Council Reference: D25/148873  
Contact Person: Justin Lamerton

25 Moss Vale Rd Bomaderry – SSD- 69257218  
Shoalhaven City Council Response to Request for Comments

I refer to the Department of Planning, Housing, and Infrastructure's request for comment in relation to SSD-69257218.

Drawing Title
Housing Precinct H - SEDA
Level 1 (Ground) Floor Plan

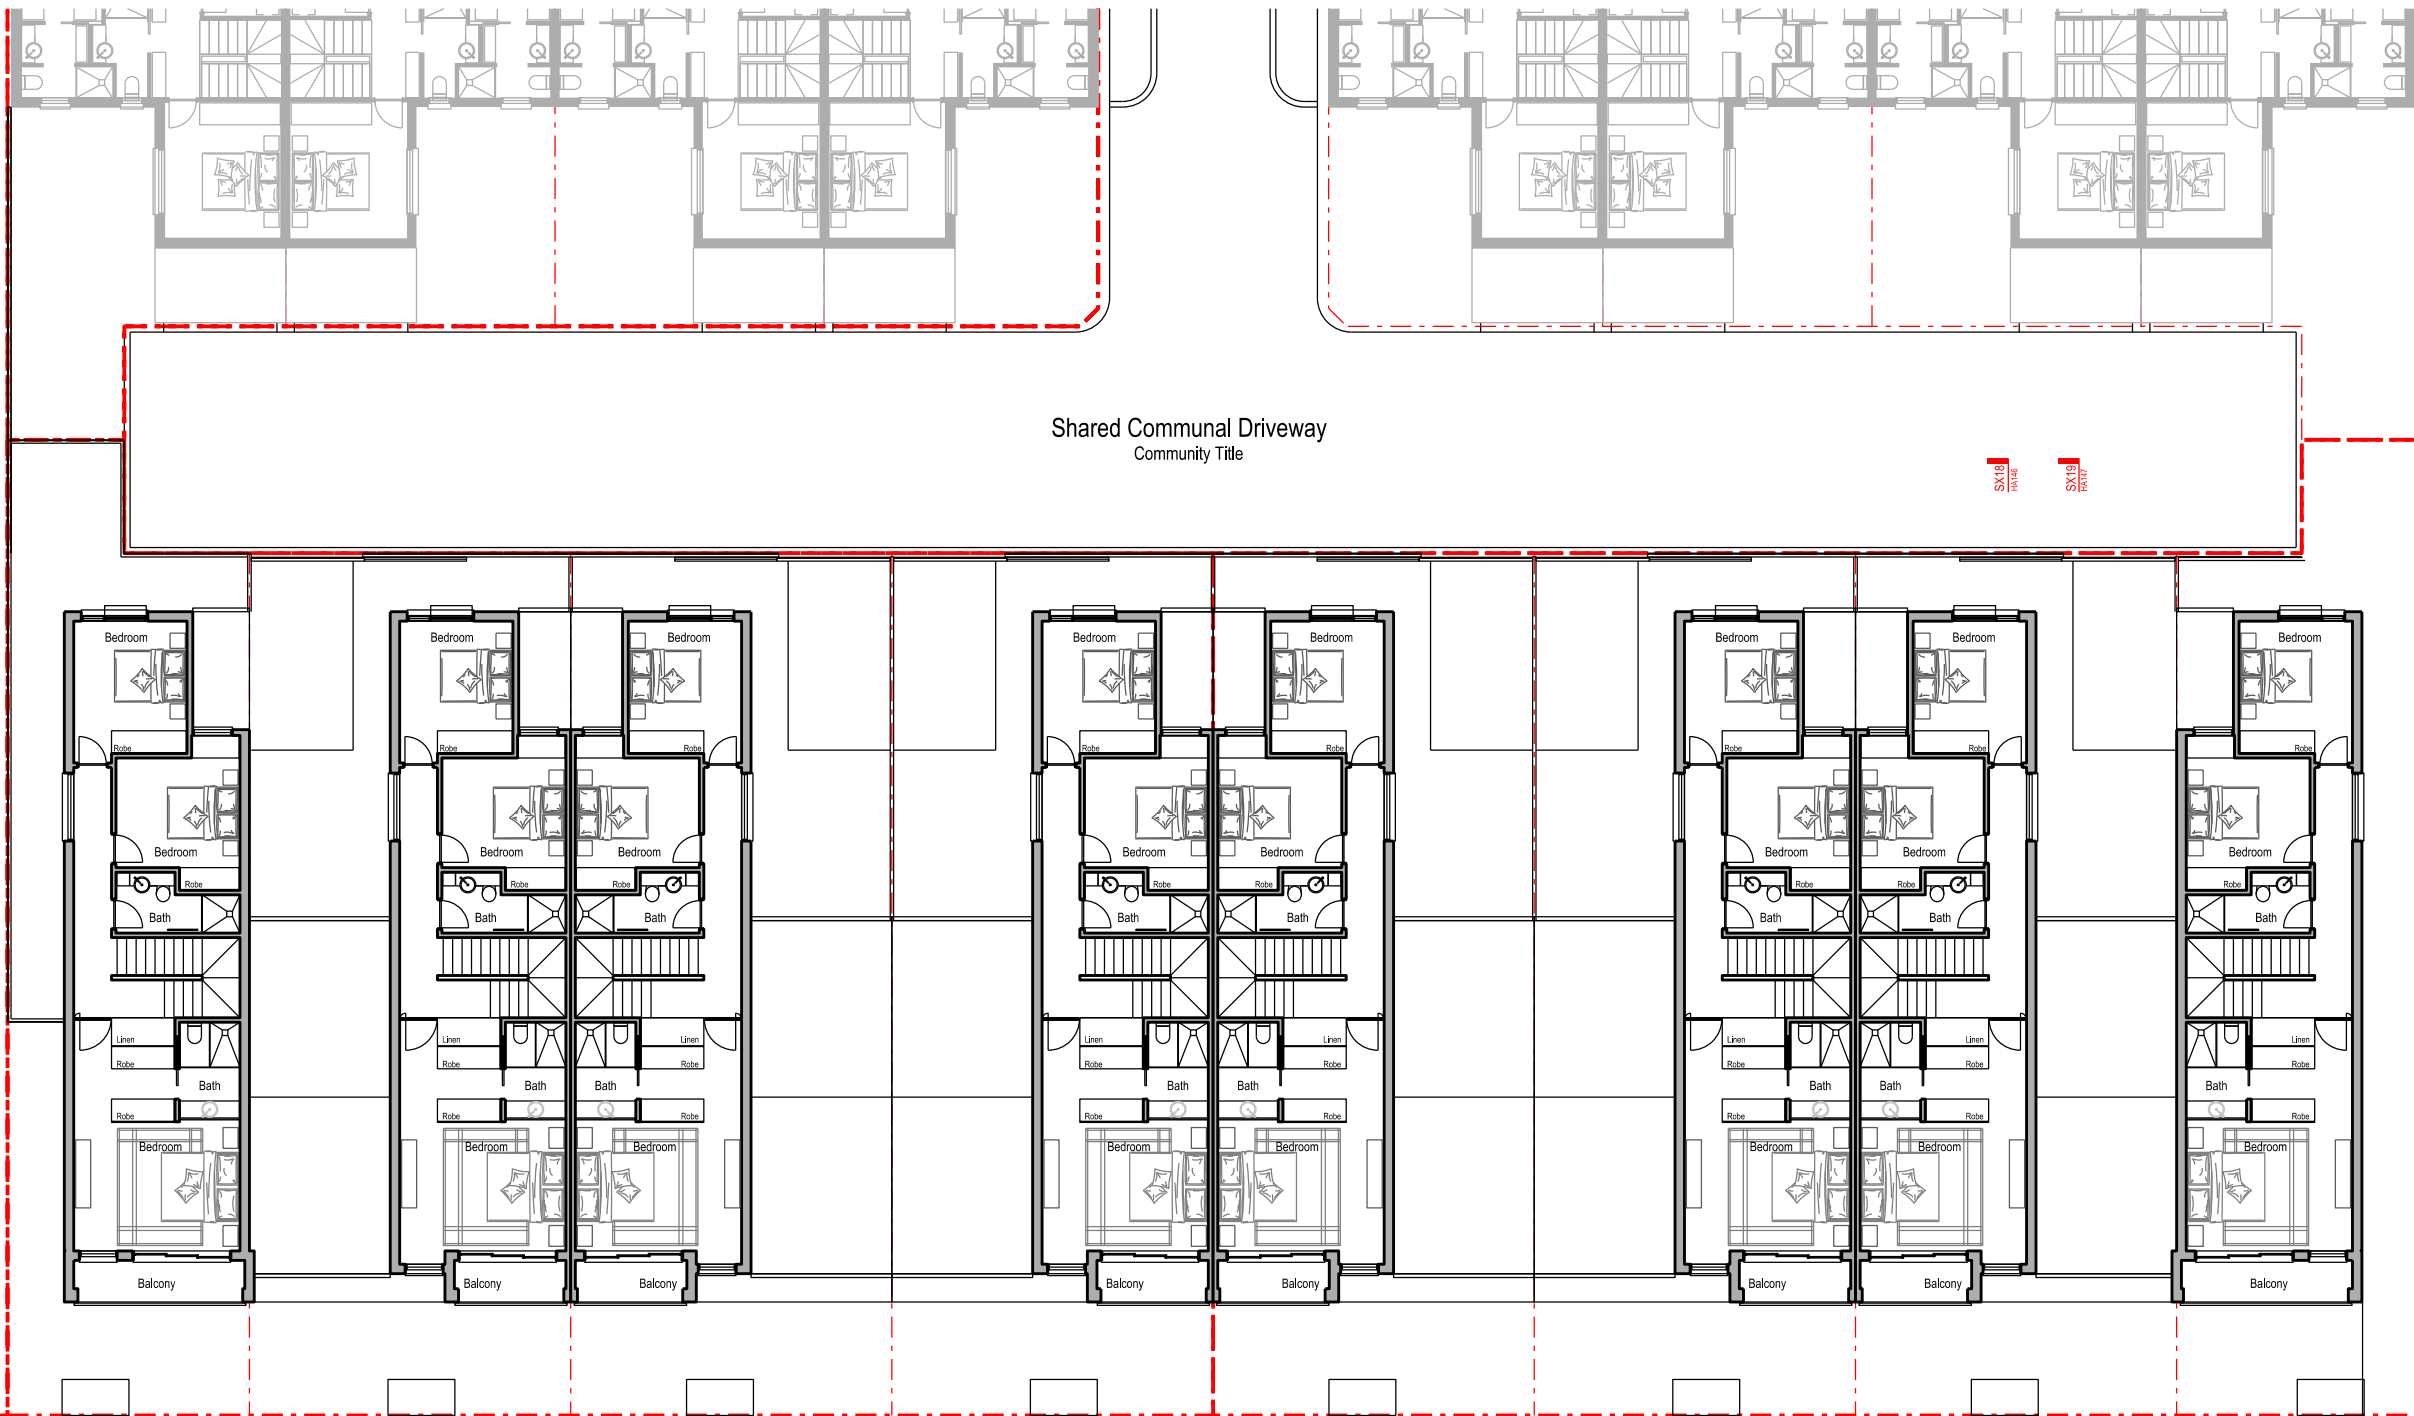
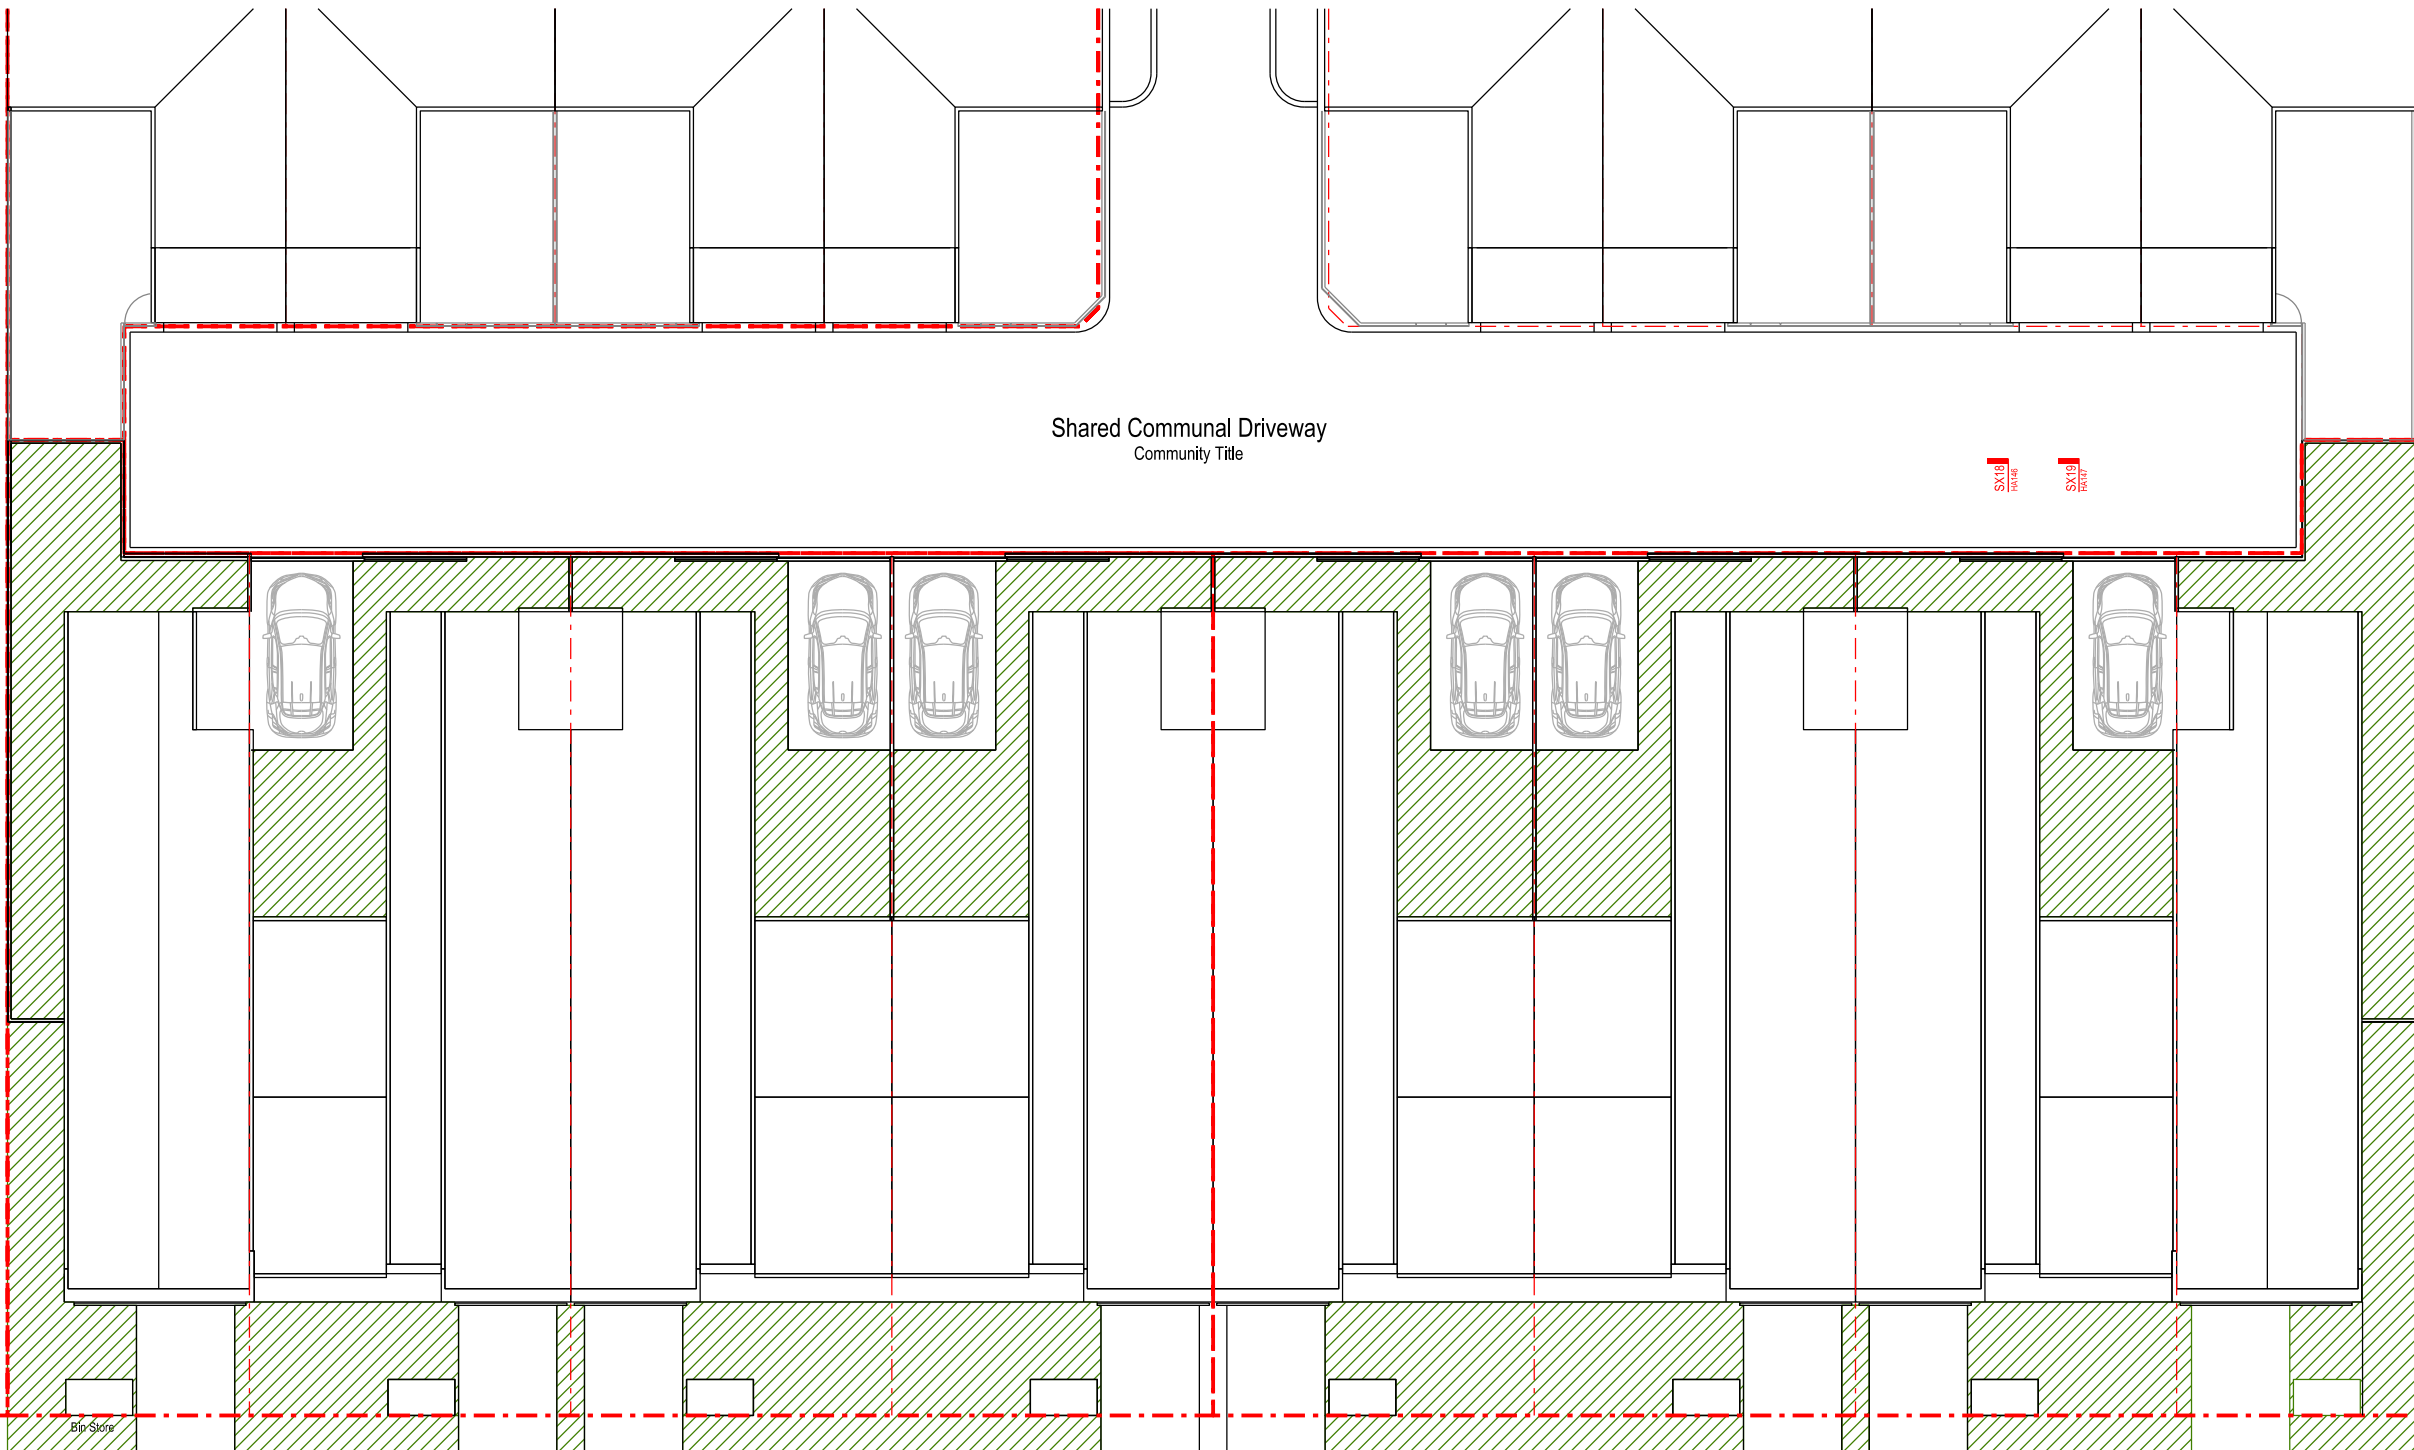
**Building H** - 8 x 3 bedroom Dwelling + 6 Studios - The waste management plan indicates sharing 2 x waste bins and 1 x recycling bin between each studio and 3 bedroom unit. It is more suitable to provide a separate bin storage area and service to allow each studio and 3 bedroom unit to have 1 x waste bin and 1 x recycling bin (standard council service) with storage space to accommodate a FOGO bin per service. There is suitable kerbside space for the 3 bedroom units to present bins to the properties southern boundary. Considering the studio's are accessed through the communal driveway it is recommended that the bin services are presented to the northern property boundary with bins from Building G.

Drawing Title
 Building Site M - SSSA
 Level 0 (Undercroft) Floor Plan

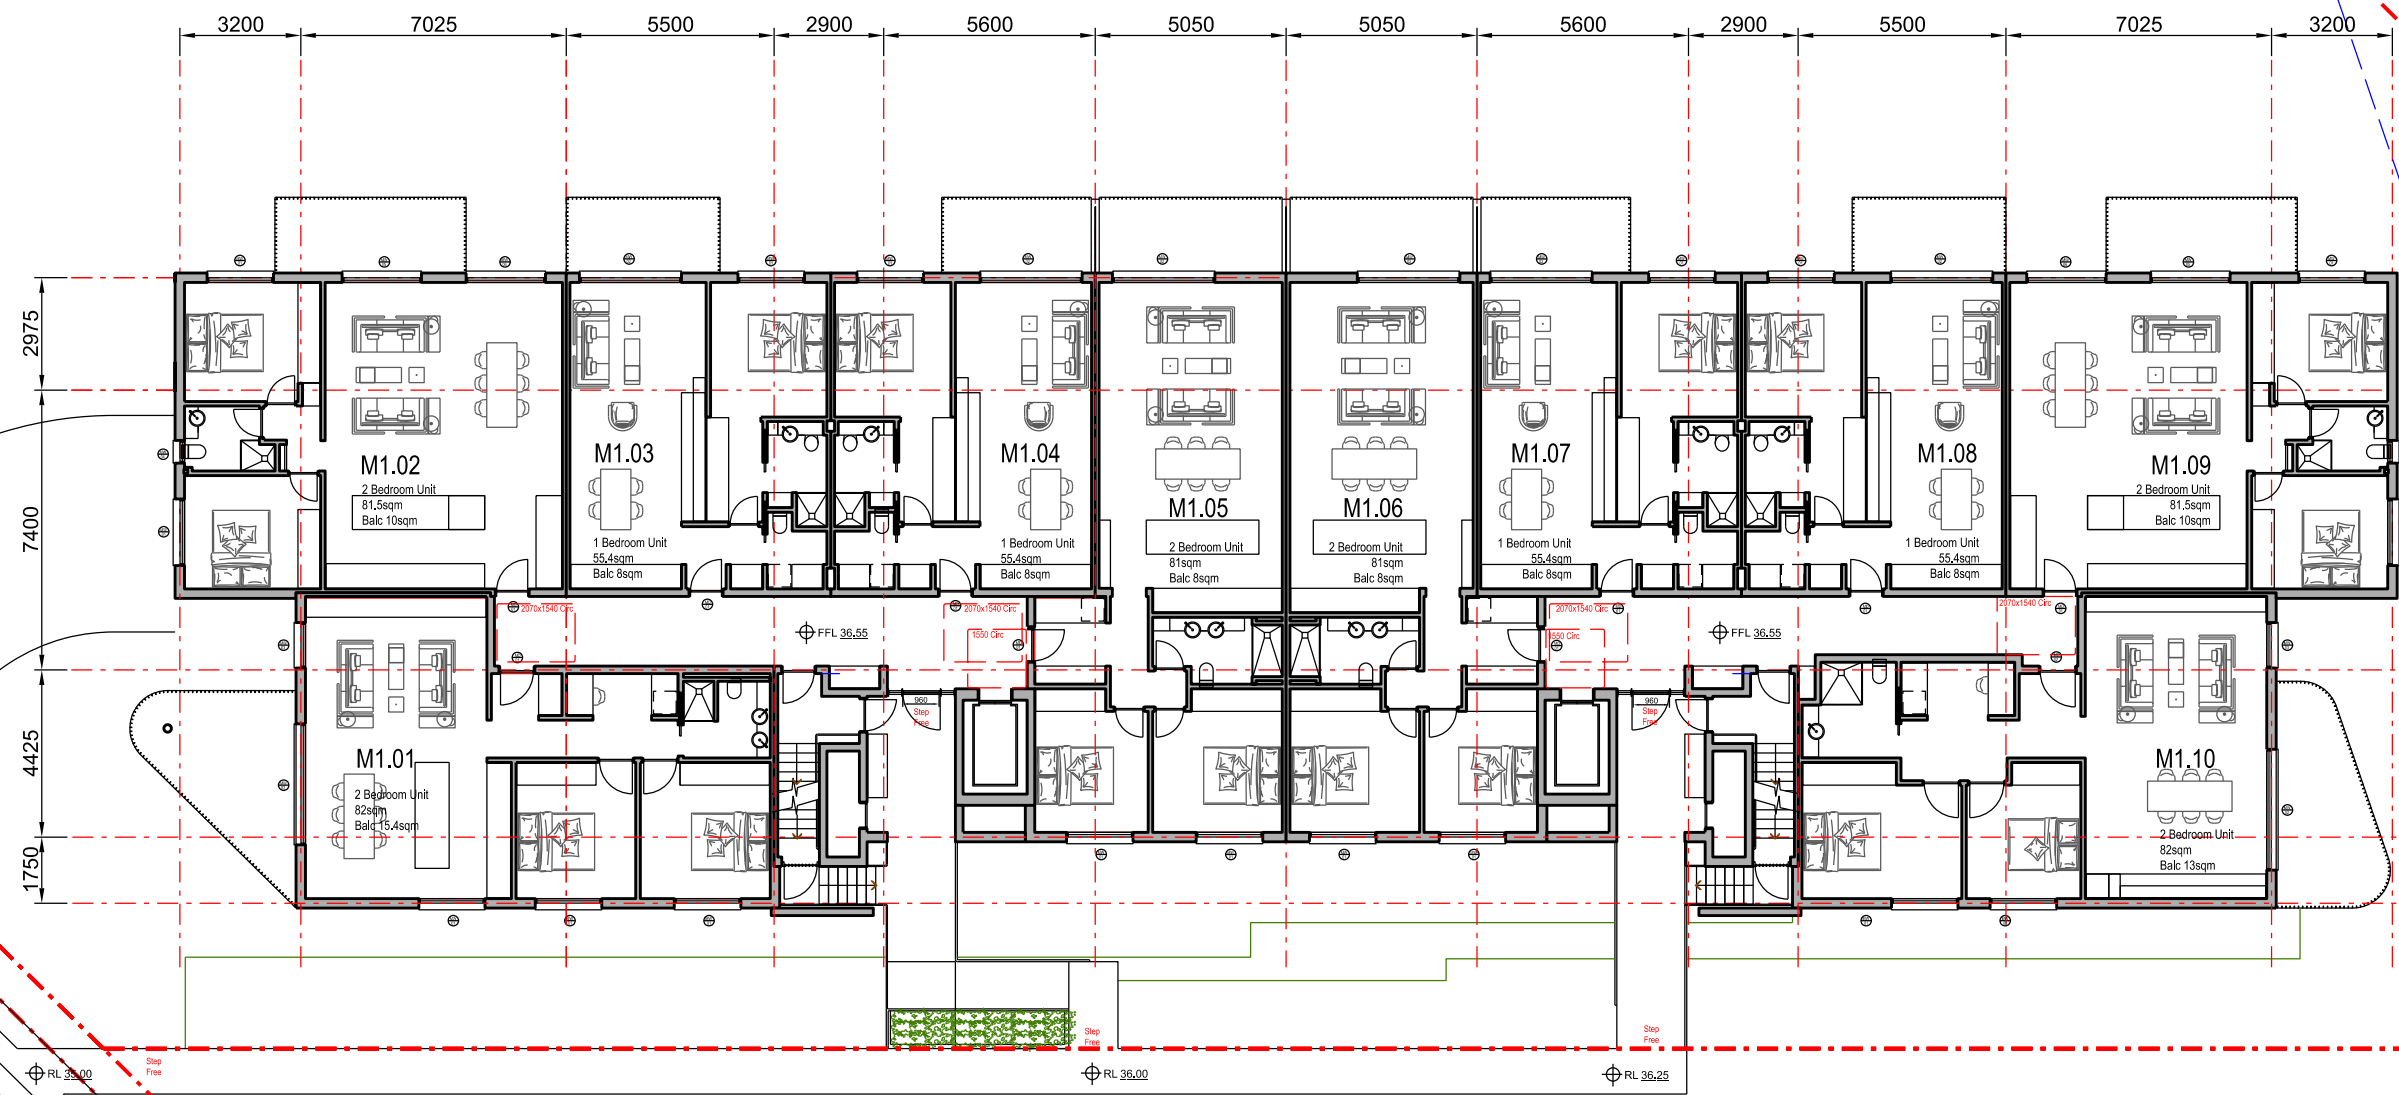
**Building M** - 30 x Apartments - It is suitable for 2 units to share a 240L waste and 240L recycling bin. The bins outlined in the residential garbage rooms are inconsistent with the 16 x waste and 16 x recycling outlined in the waste management plan. The bin storage room needs to be suitably sized to accommodate the 32 bins including additional space for the introduction of FOGO bins without any bins being stored stacked in front of each other. Further information is required detailing how

these bins will be serviced, including bin movement paths with a preference for an onsite waste and recycling collection service provided by a private waste collection contractor.
